Your ref:
Our ref: 22/01719/F
Please ask for: Amy Davies
Direct dial: 01553 616879
E-mail: borough.planning@west-norfolk.gov.uk

18 October 2022

Details: **Proposed Stables & Menage. Change of use from agricultural to residential. at Camsiscan Station Road Walsoken WISBECH Norfolk**

Location Plan  
Scale: 1:1250

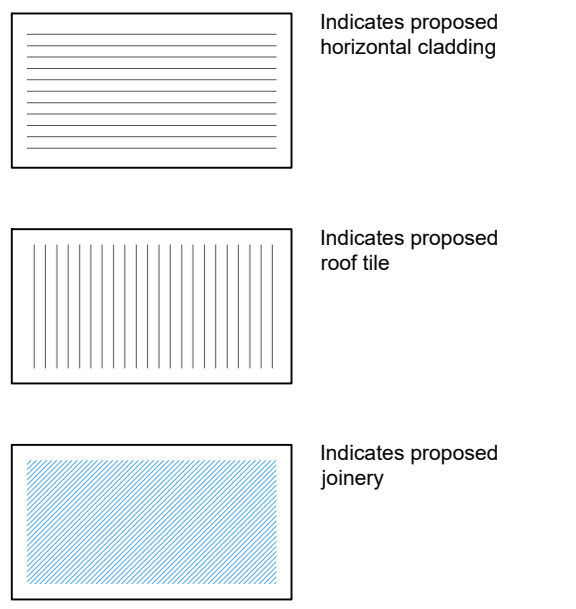
1. For applications for the construction of stables, in an area at risk to flooding, the Environment Agency ask for a statement to include the following information to be submitted to the Local Planning Authority.
 1. confirmation that the applicant is aware that the area is at risk of flooding
 2. where will the horses will be evacuated to in an emergency
 3. how will the horses will evacuated in an emergency
 4. that the applicant is aware of the flood warnings available
2. We have received a payment for £924.00 this covers the cost of the stable block you are proposing, unfortunately the Manage has a separate cost of £702.00, However if you wish to put in a separate application for just the menage showing a blue line around the whole site and a red line just around the menage this cost will then be £234.00 .
